Reference	Respondent(s)	Question	Response
1. Miscellaneous and General			
MG1.1.14	The Applicant	<p>In the Onshore Outline CEMP [APP-505] at 6.3.5.9, a 'Temporary Site Water Management Plan' is 'proposed' to be developed and approved prior to commencement of construction work. Does the Applicant believe that this paragraph would be sufficient to secure its production through the DCO?</p> <p>Should an outline management plan be provided as an Appendix (similar to those at Appendices 3, 4 and 5 for the Outline Site Waste Management Plan, Outline Materials Management Plan and Outline Soils Resources Plan respectively) or, as a minimum, a framework to clarify the intended content?</p>	<p>Hampshire County Council (HCC), in its role as Lead Local Flood Authority, seeks an outline management plan to be provided in relation to the Temporary Site Water Management Plan. This should be provided prior to the determination of this application in order to provide the reassurance that the treatment of water associated with the temporary site works can be suitably addressed.</p>

2. Air Quality			
AQ1.2.3	Hampshire County Council	<p>Are there any updates or results emerging from the Inquiry commis

Aquid Countryside Option

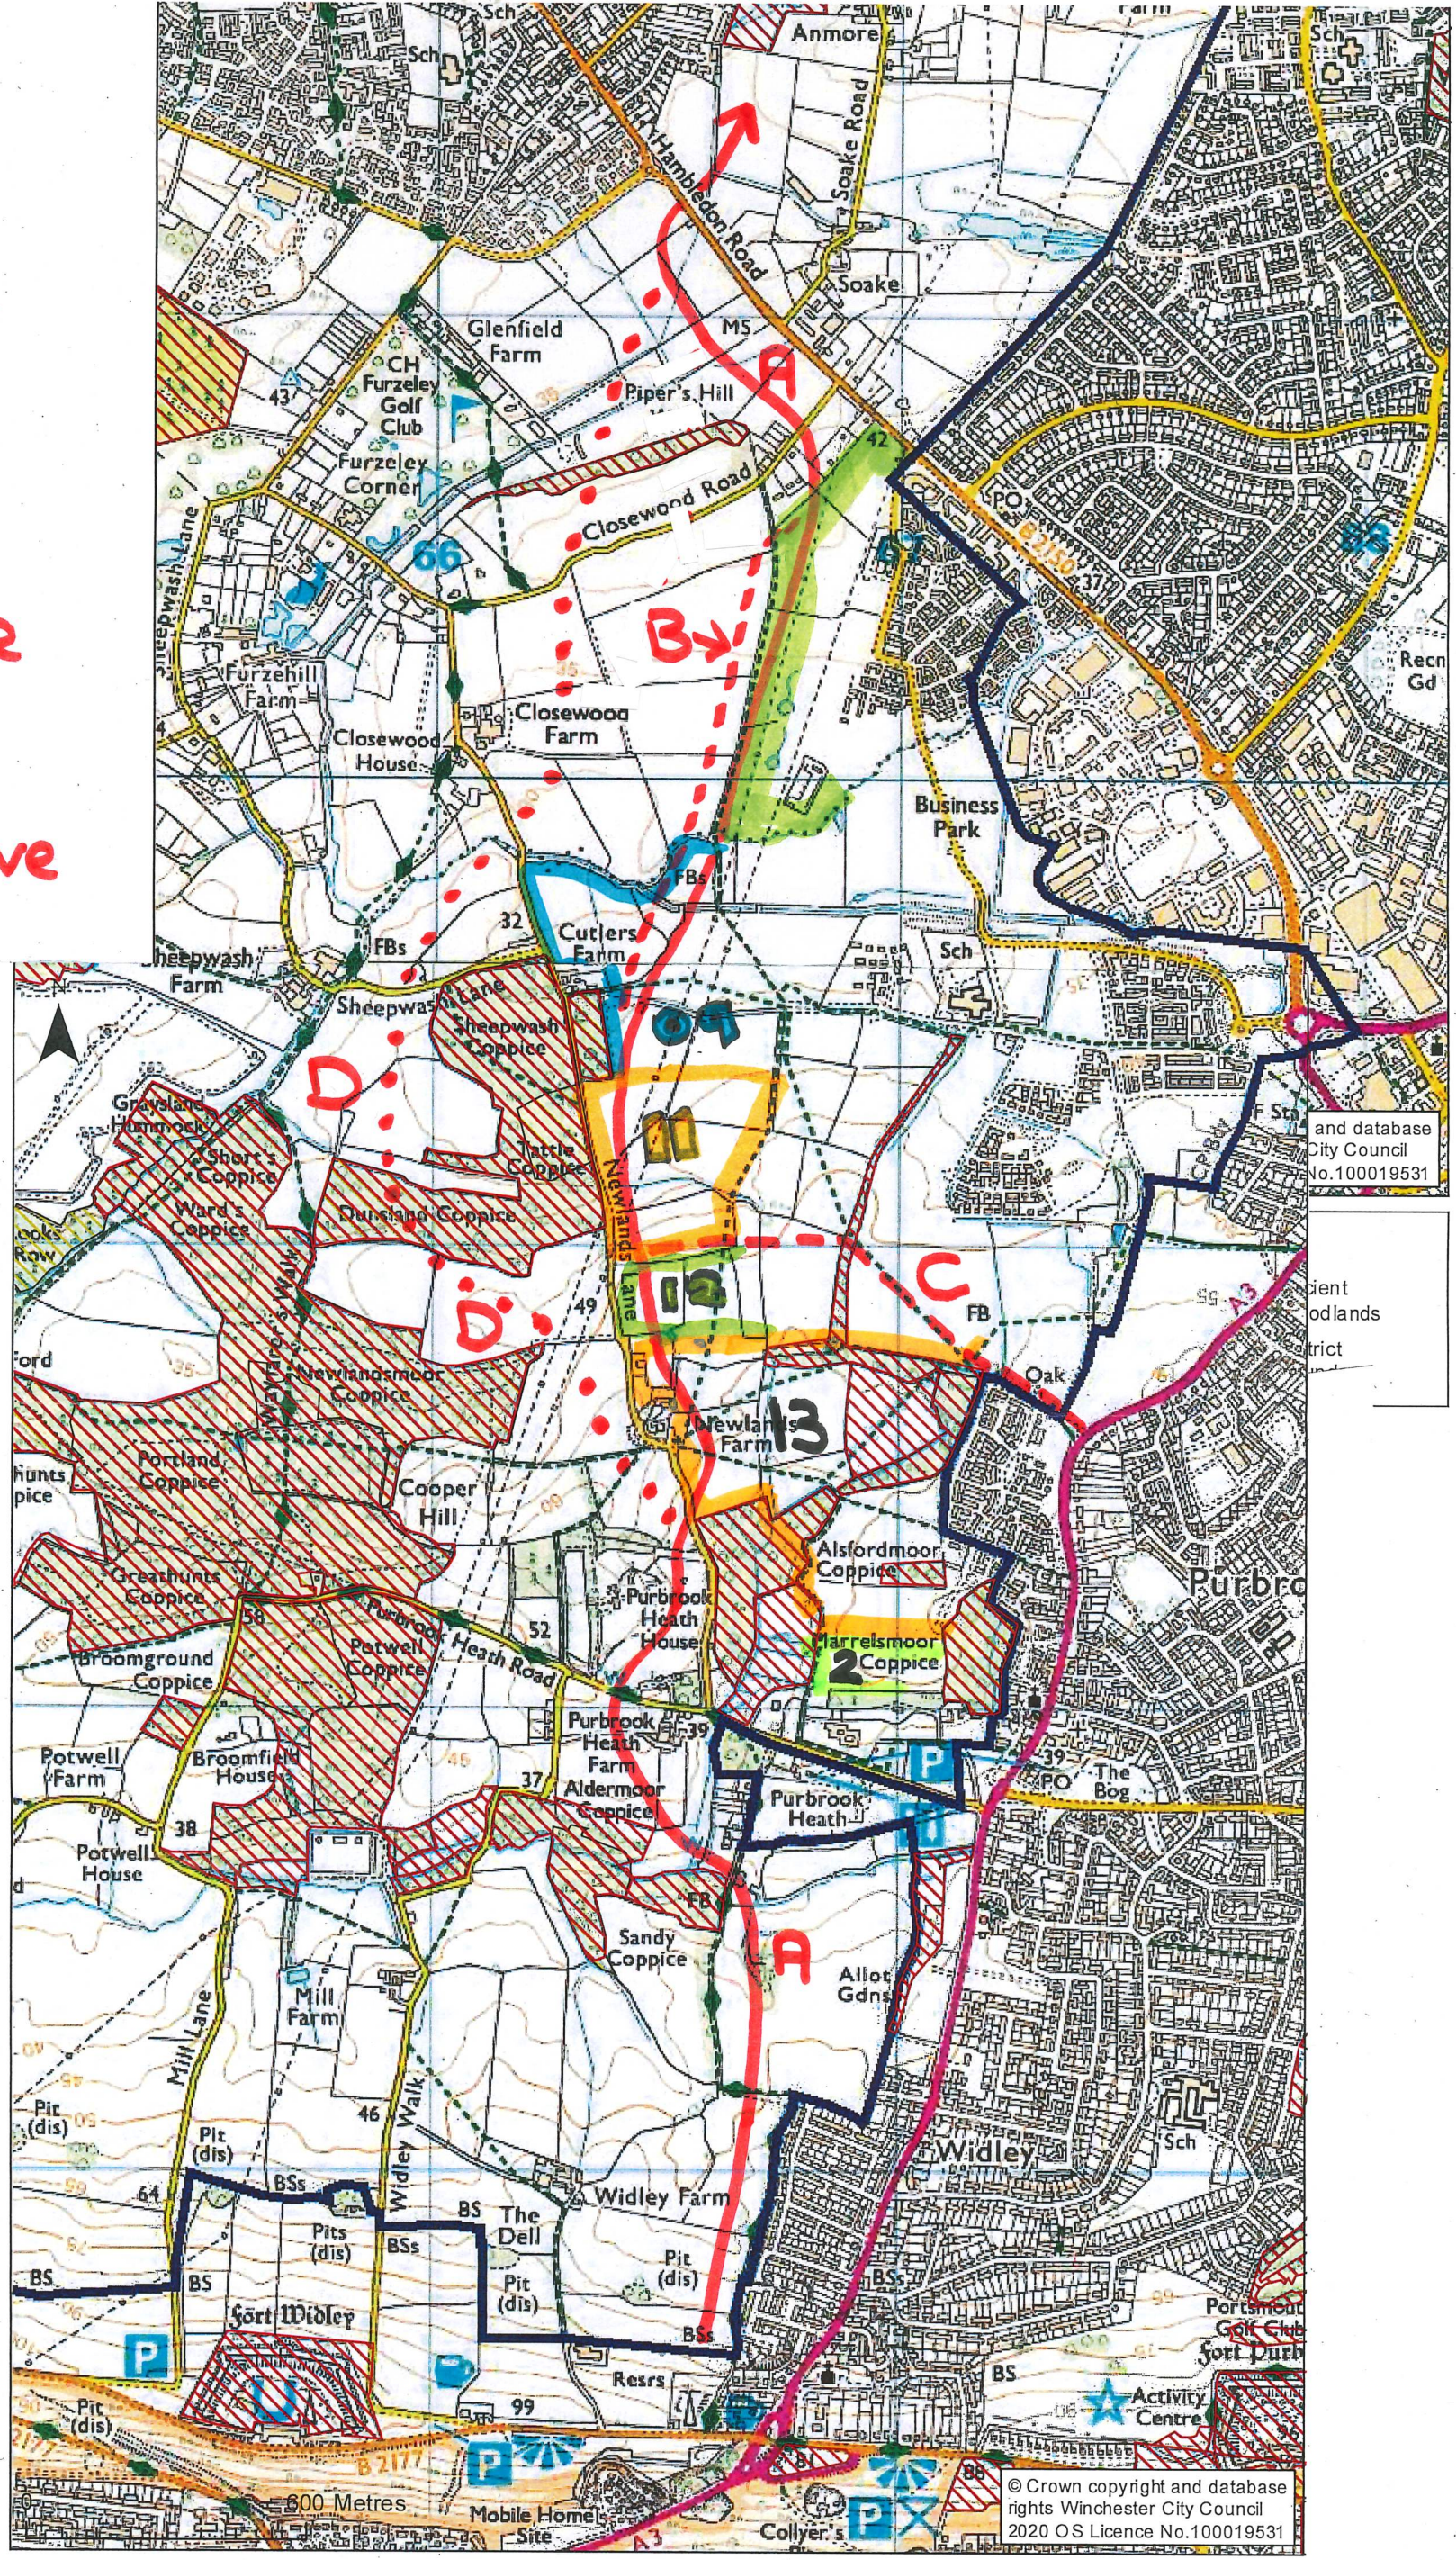
CA1.3.105	Winchester City Council	For the alternative cable routes shown in the application at Anmore Road (Paragraph 5.3.5 of the Statement of Reasons [APP-022]), which route would	It is understood that the preferred option of Winchester City Council is to use the straight crossing for both cable circuits, as an extension of the route through King's Pond Meadow. The Highway Authority would support this in reducing the

Reference	Respondent(s)	Question	Response
		<p>the Council prefer to see utilised, or have the least objection to, and why?</p>	<p>length of cable route within the highway and to minimise the length of cable within the highway.</p> <p>It is not clear why horizontal drilling is not being utilised to cross Anmore Road given the proposed drilling through King's Pond Meadow. The Highway Authority would prefer methods and routes to be used which reduce the impact of road closures and therefore impact on residents and users of the Highway.</p>
<p>CA1.3.107</p>	<p>Winchester City Council</p>	<p>For the alternative cable routes shown in the application at Anmore Road (Paragraph 5.3.5 of the Statement of Reasons [APP-022]), what are the Council's views on whether the regulation provided by dDCO [APP-019] Requirement 6(2), together with the addition of an article similar to Article 19(5) and a requirement similar to Schedule 1 Part 3 Requirement 12 at Appendix D of the Examining Authority's Recommendation Report for the Thanet Extension Offshore Wind Farm Nationally Significant Infrastructure Project</p> <p>https://infrastructure.planninginspectorate.gov.uk/wp-content/ipc/uploads/projects/EN010084/EN010084-003108-</p>	<p>The Highway Authority refers to its comments on CA1.3.105. Given that the examination has only just commenced, we would expect the Applicant to have further explored these options and identified a preferred route prior to the close of the Examination. In the event that this is shown not to be feasible, the Highway Authority would value the opportunity to offer advice on suitable wording within the DCO.</p>
